**APPLICATION NO:** 20/01082/FUL/ADDINF

**DESCRIPTION:** Erection of 1 No. detached dwelling following demolition of existing bungalow plus erection of annexe.

**LOCATION:** Breamar 1 Richmond Road College Town

Proposed Roof Plan  
Scale 1:50

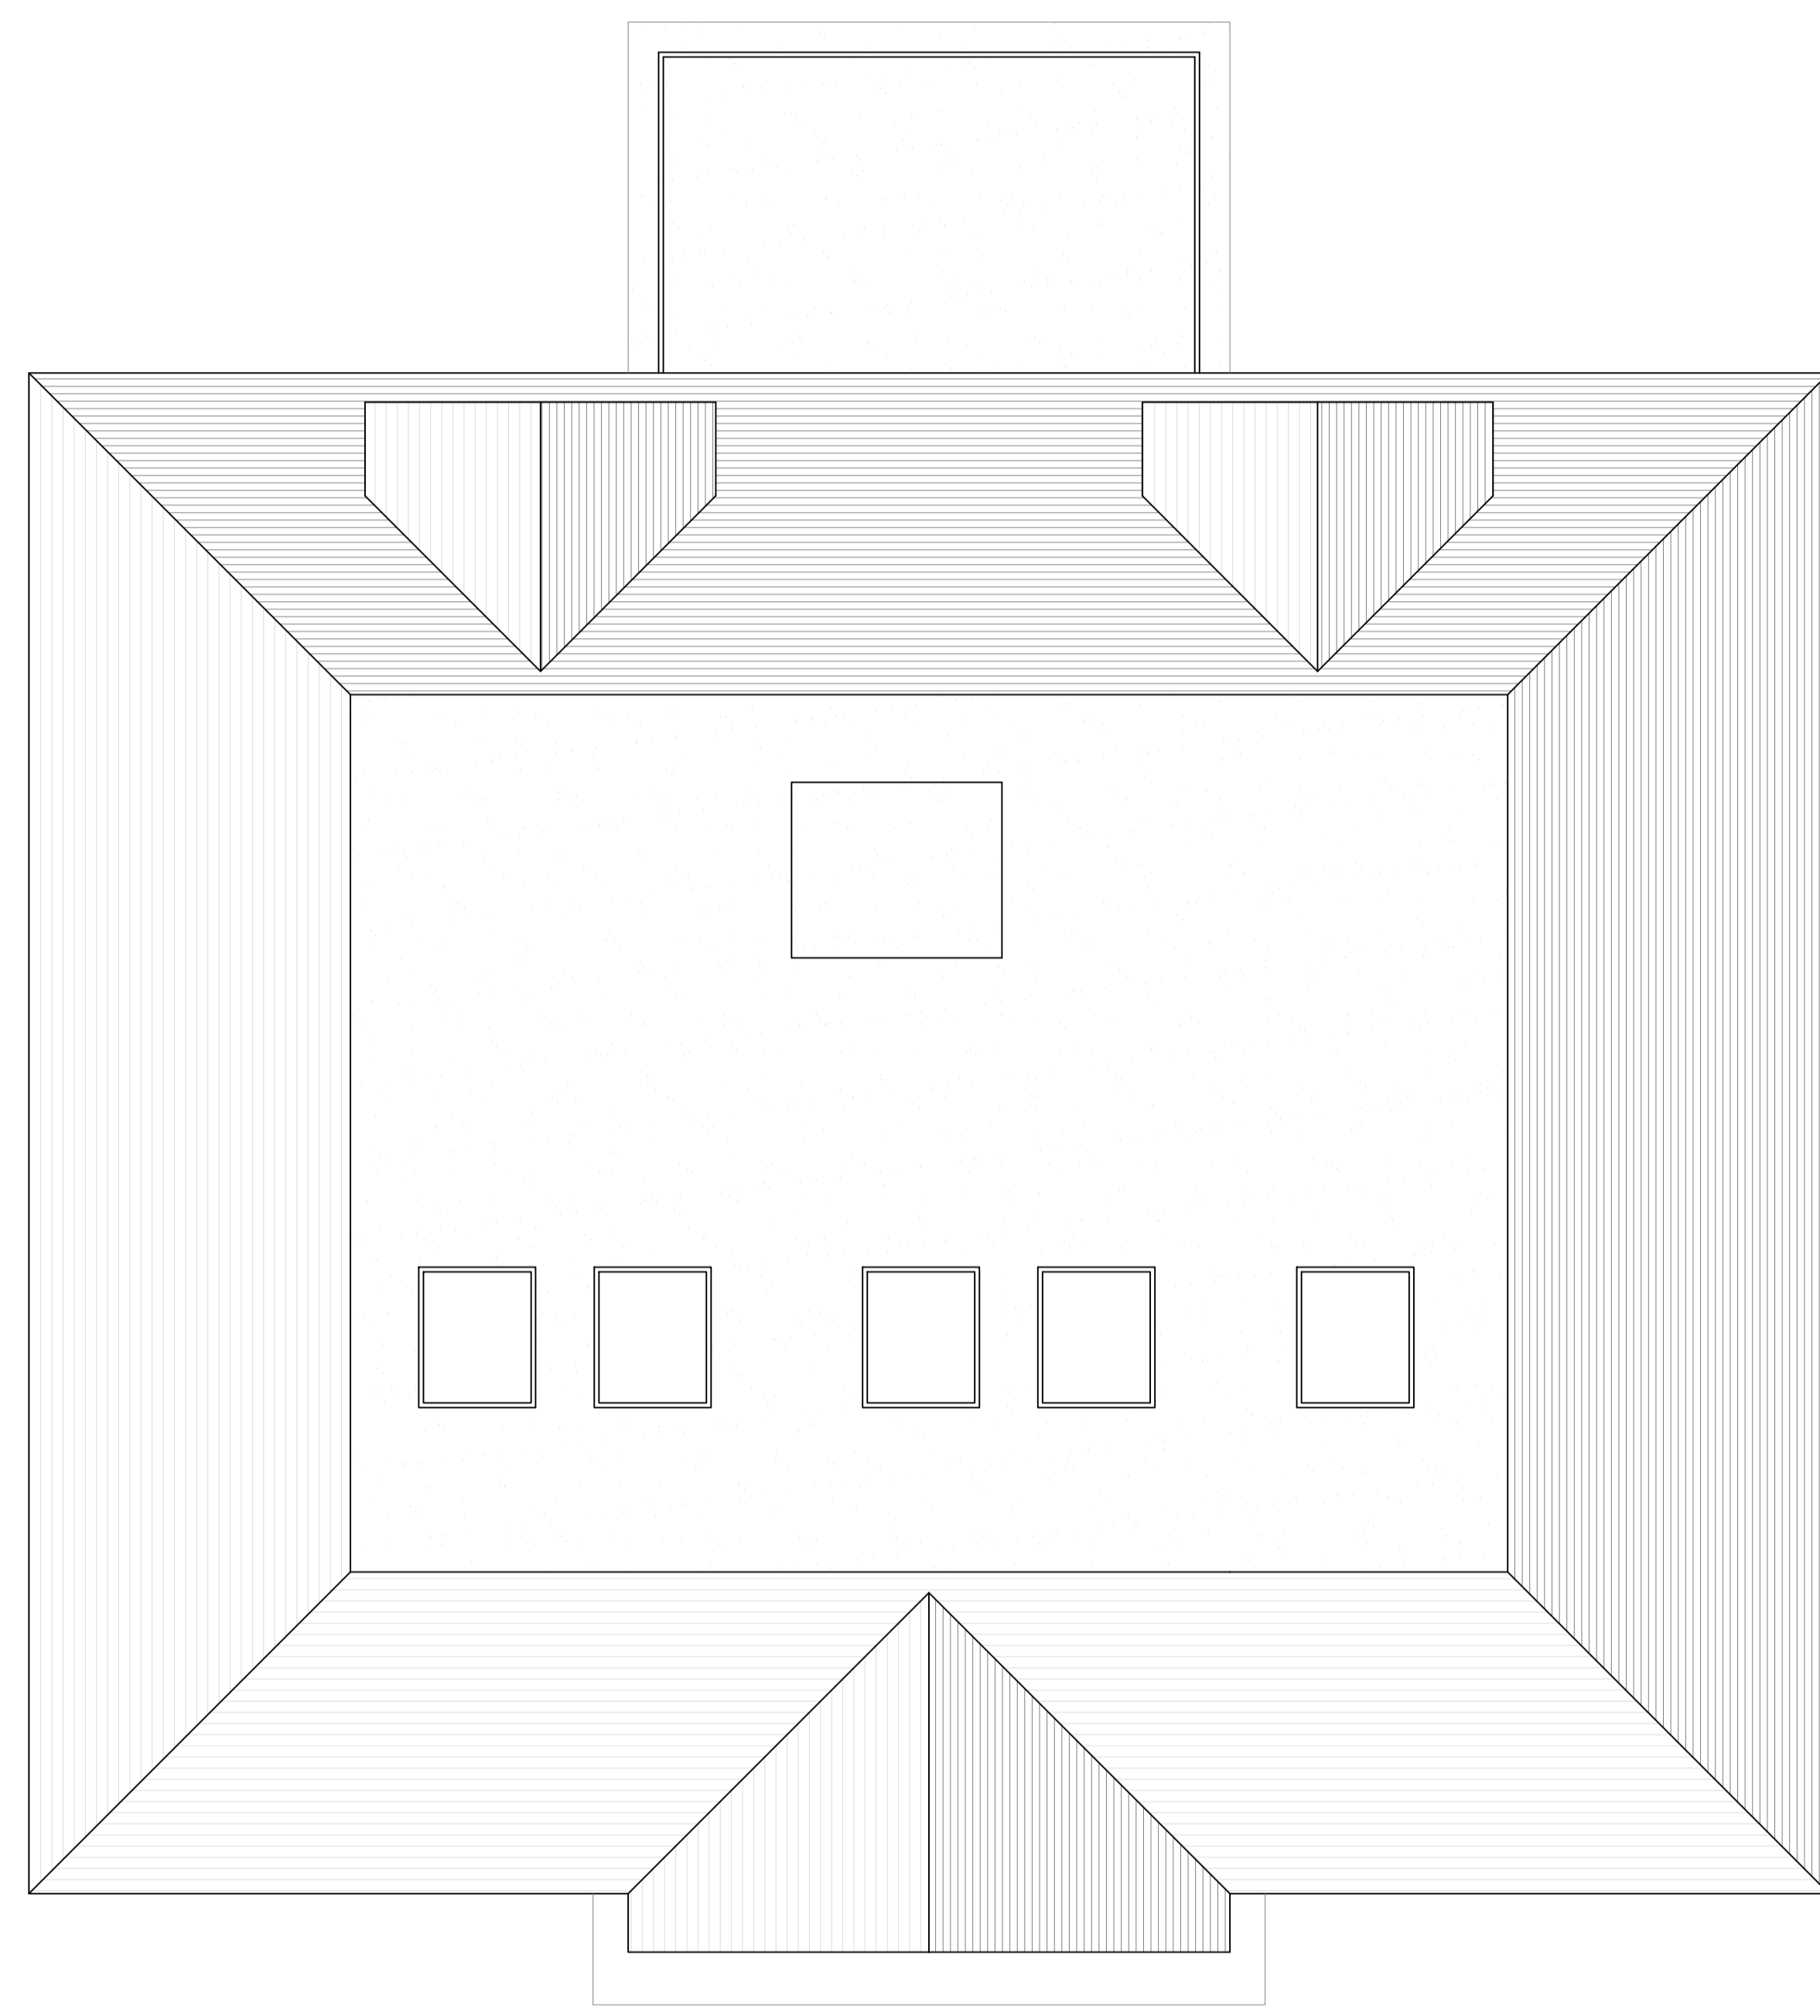
- 1 Please submit a parking plan.
- 2 Please confirm whether the roof lights will be flush.
- 3 Please confirm whether the annexe will be used ancillary to the main dwelling.
